**Case Officer:** Catherine Harker

**Recommendation:** Approve

**Proposal:** Internal and external alterations to an existing detached dwelling including Internal layout changes, remodelling of the front entrance porch, new dormer windows to front of main house, conversion of existing attached barn to an annex/studio and construction of a new detached garage/workshop and site landscaping

Drawing Title:
Proposed Garage Plans

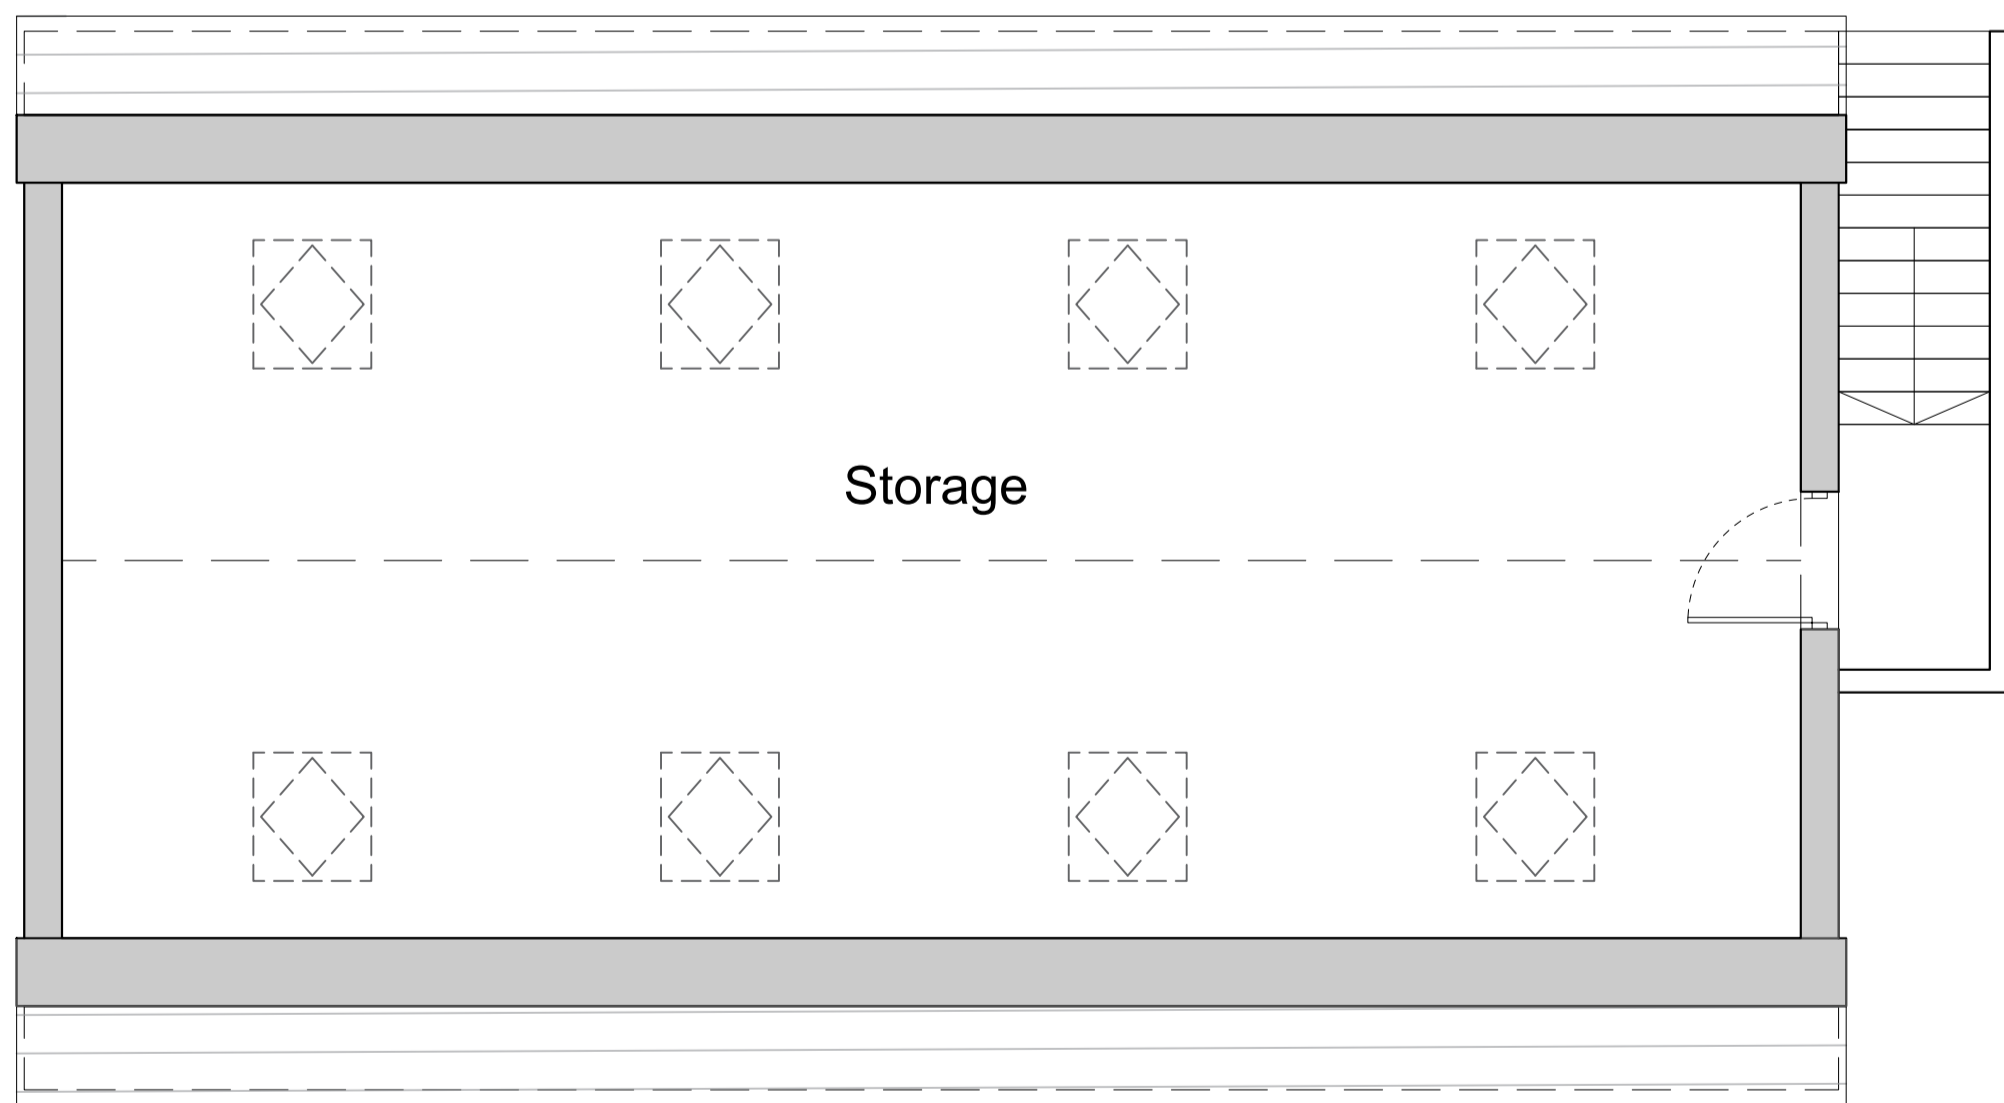
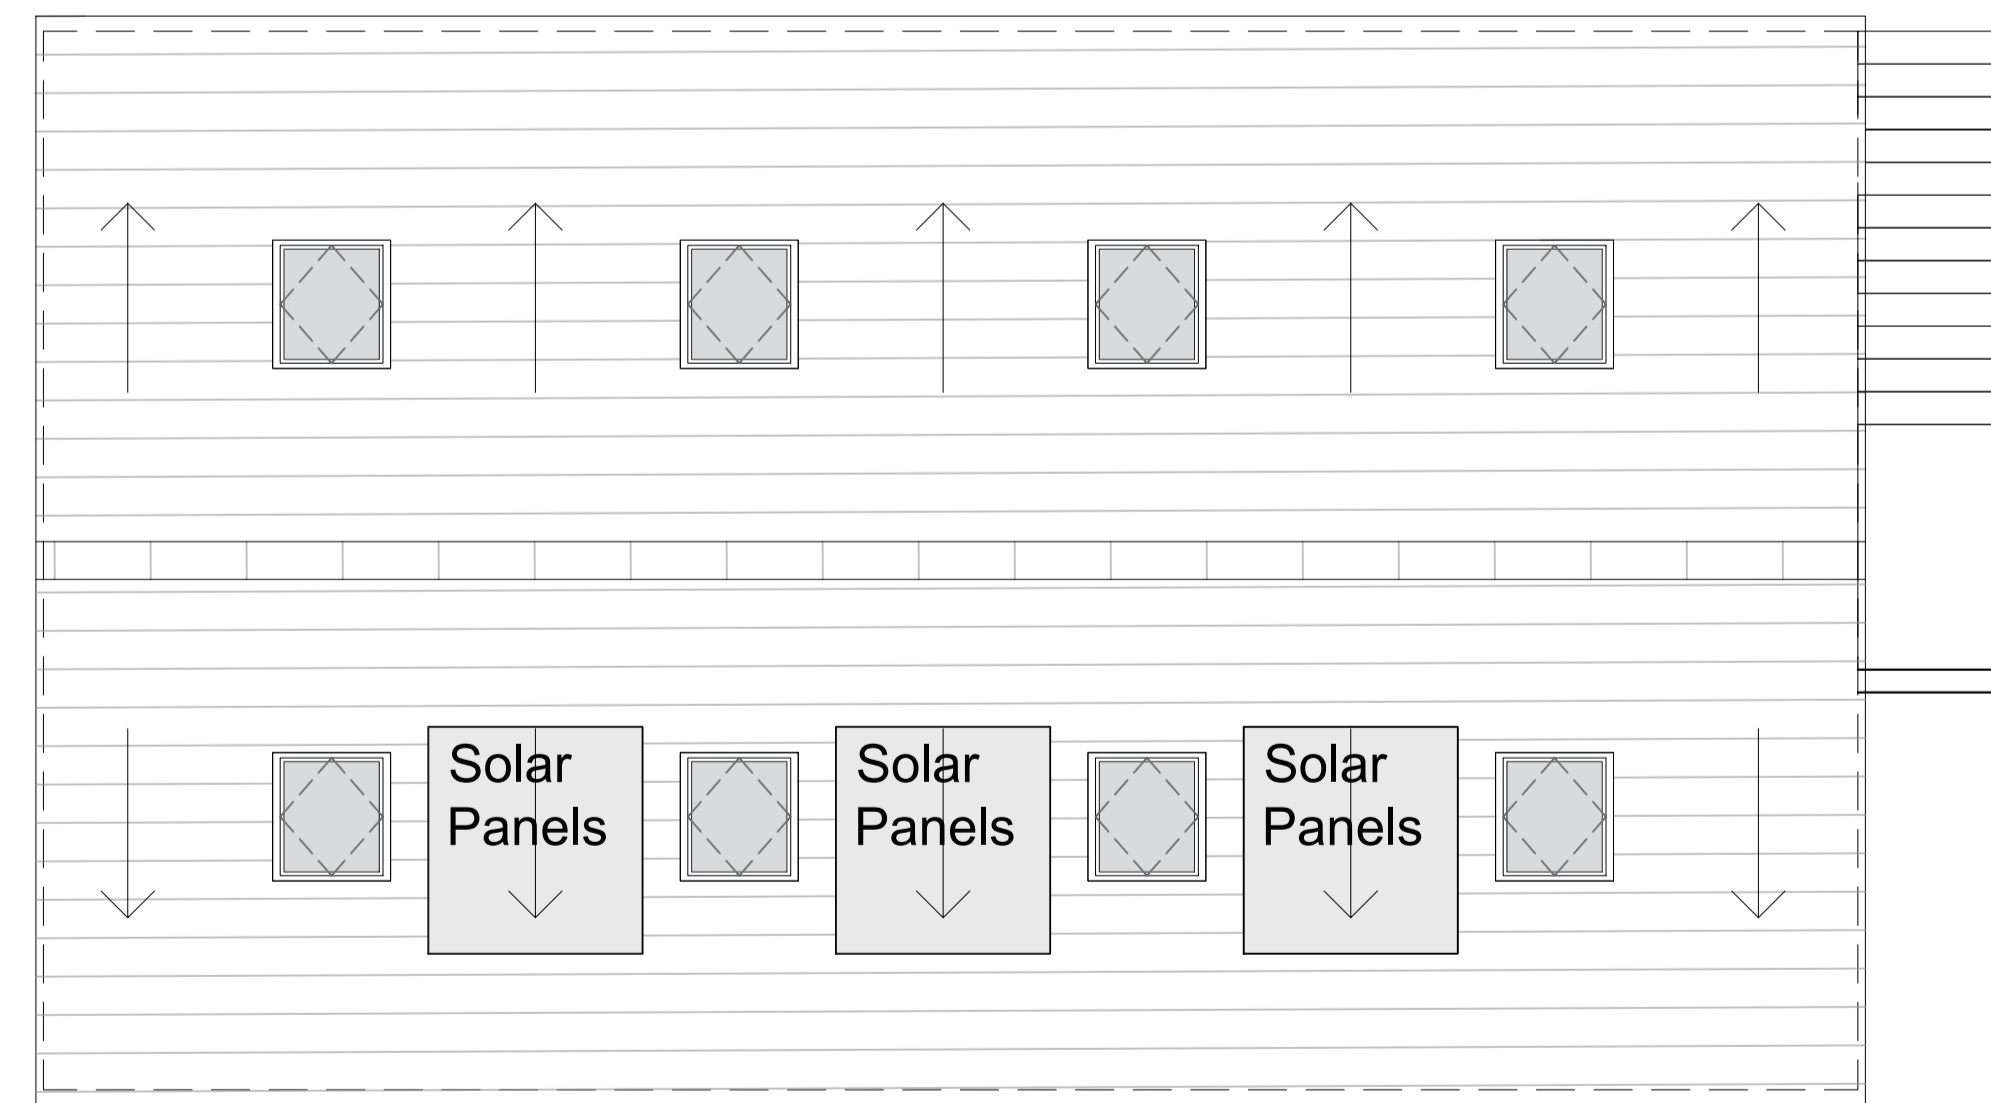
The proposed garage would be approx. 7m x 12m x 6m high. This is quite large, but it would still be subservient to the much larger sprawling dwelling, and would not be readily visible from the road, being screened by the host dwelling, attached barn and neighbouring buildings. It would not harm the visual amenity of the street scene.
